9 BROADMARK BEACH.
BROADMARK LANE
RUSTINGTON
W. SUSSEX

PLANNING APPLICATION R/105/15/PL

JOB number:	drawing number:	revision:
2082	(11)001	1
project:	Princess Marina House	
client:	Seaside Apartments	
client:	RAF Benevolent Fund	
title:	Parking Plan	
date:	22/04/15	scale:
	1:100 @ A1	drawn: GT
		checked: CS

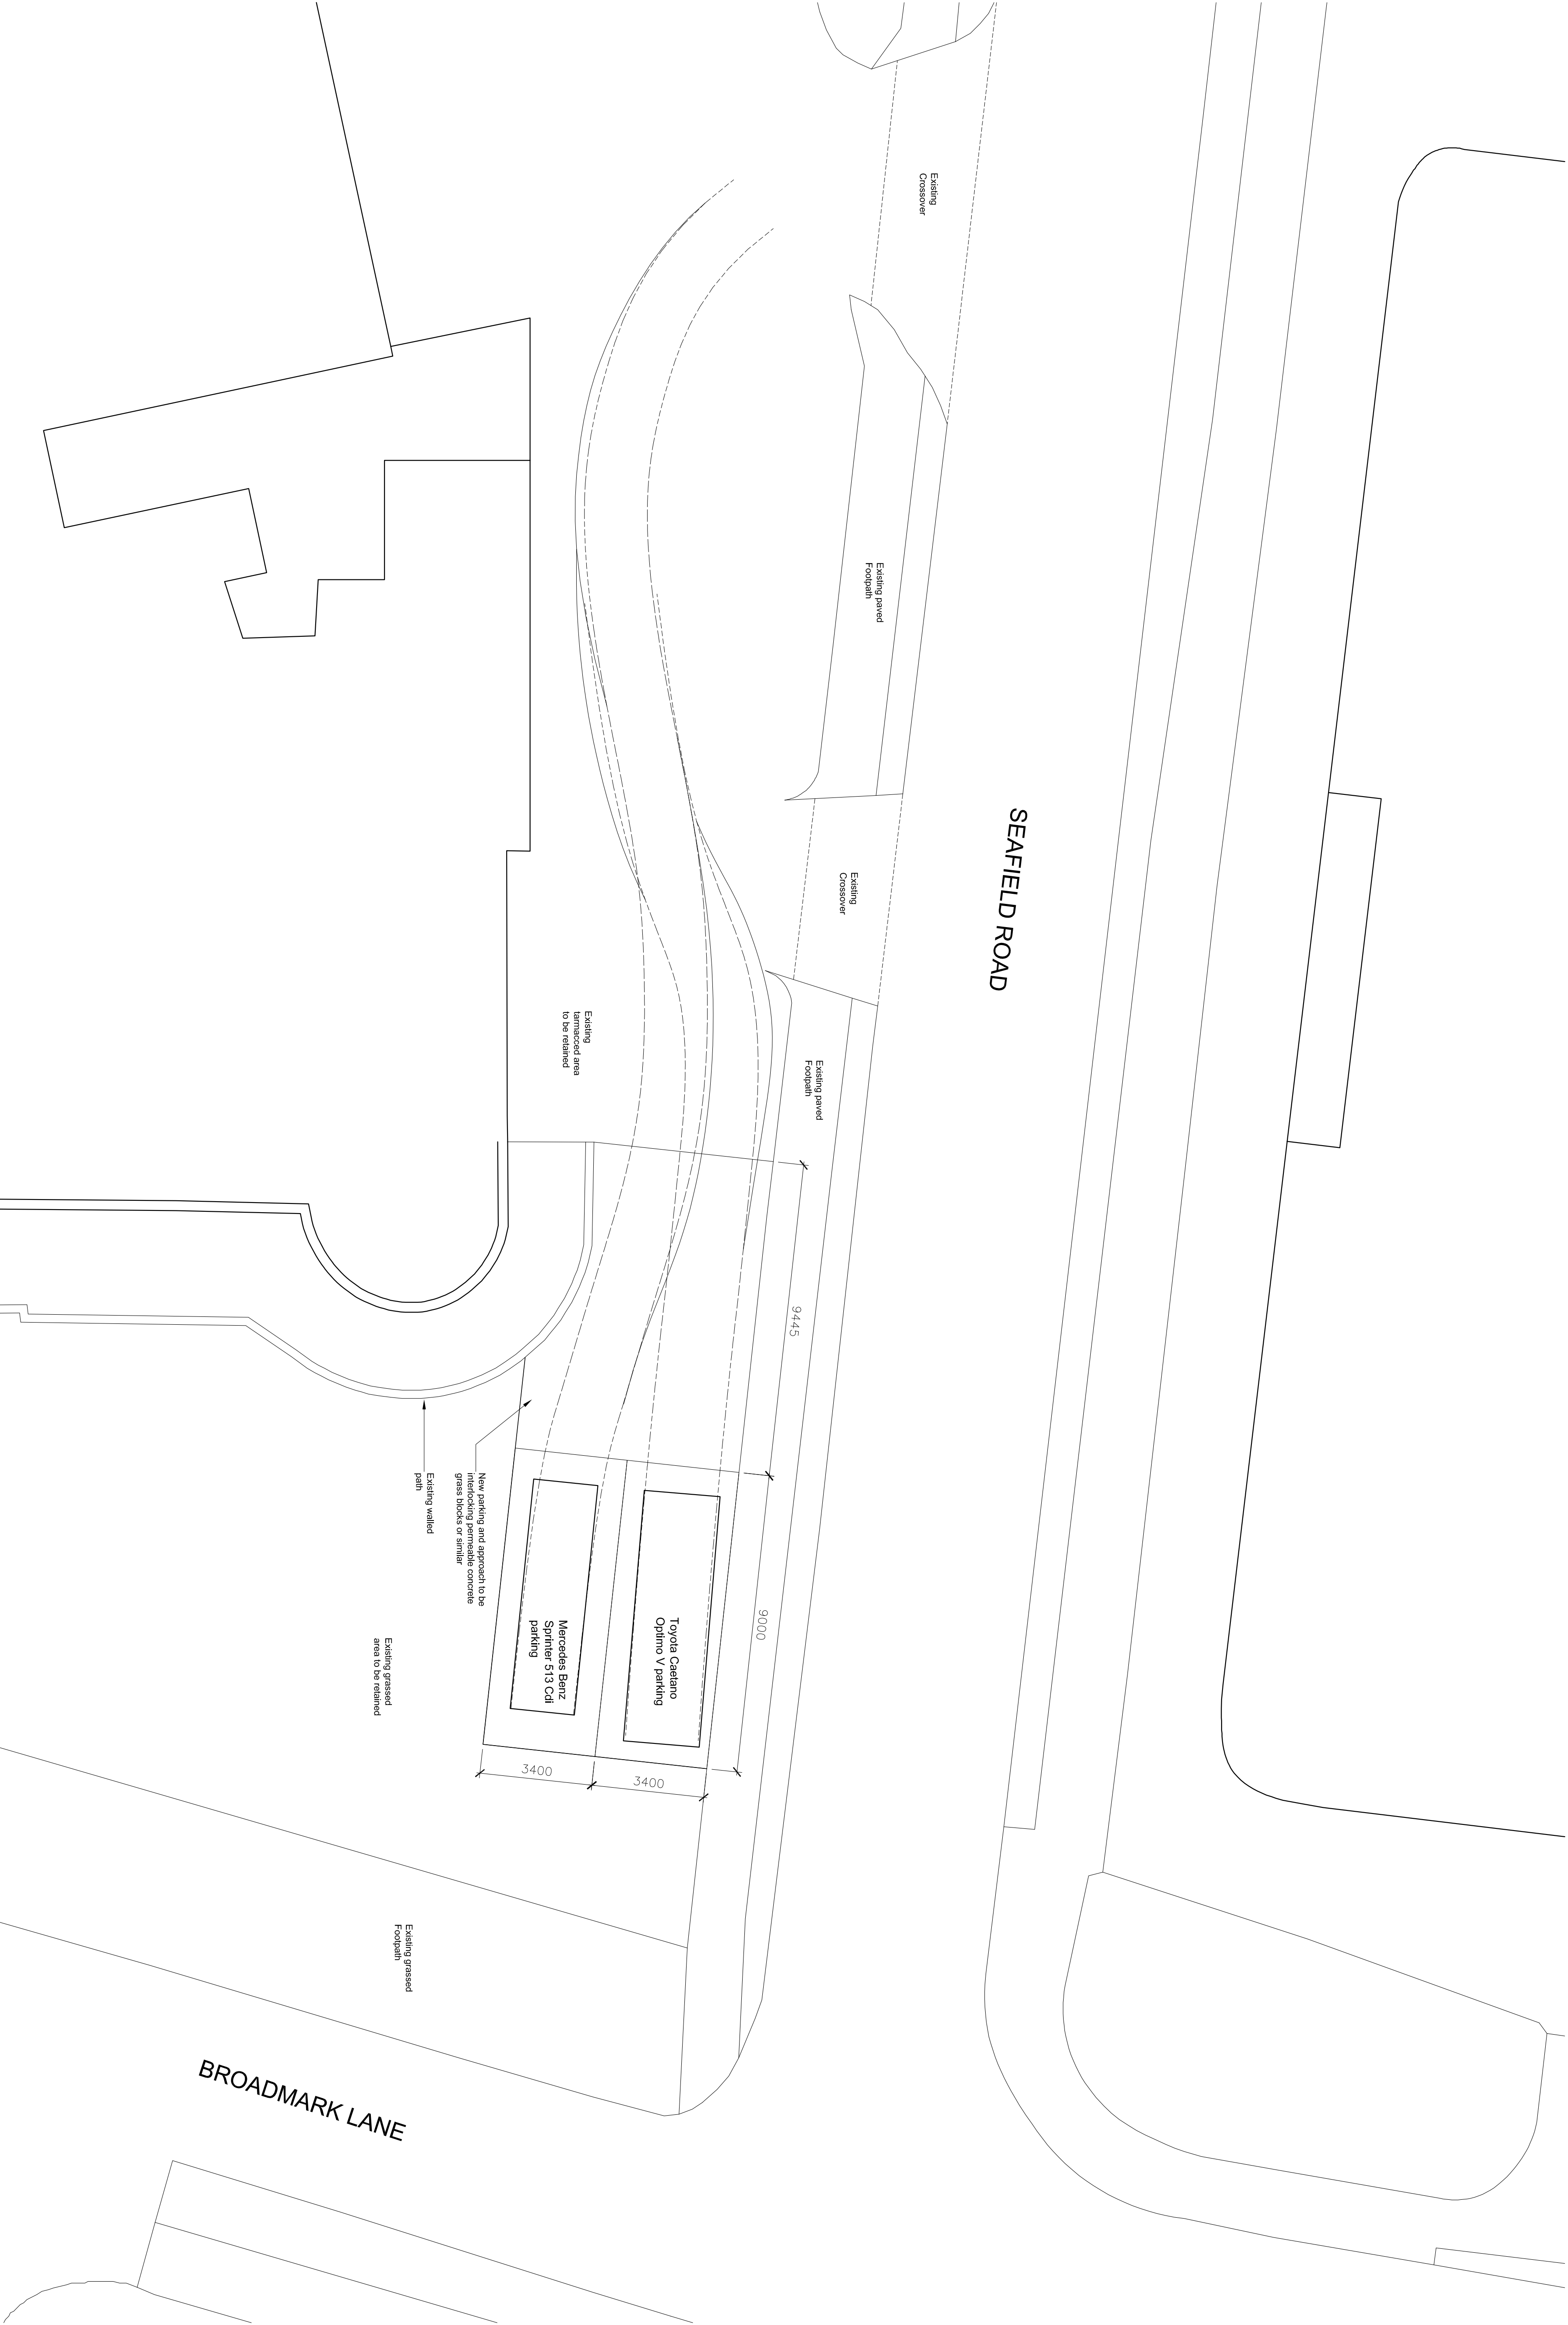
- a) It would be of no advantage to the parking of the mini buses as the access required (where they park now) would be needed at all times. No extra parking spaces would be gained.

- b) The detrimental visual effect would be most notable. It would appear that two minibuses were parked in the front garden!
- c) The applicants in a previous planning application some years ago extended part of the building into the car park. When asked about the effect of a smaller car park, the applicants stated they would encourage the staff to cycle to work. Over the years I have yet to see even one bicycle enter or leave. (I overlook Seafield Rd and Princess Marina House.)
May I just add that as an EX R.A.F. pilot myself (many years ago) my attitude to the considerable development that has taken place over the past years has been to date, mainly sympathetic. But I now find this latest application unnecessary and what might be termed "a bridge too far"
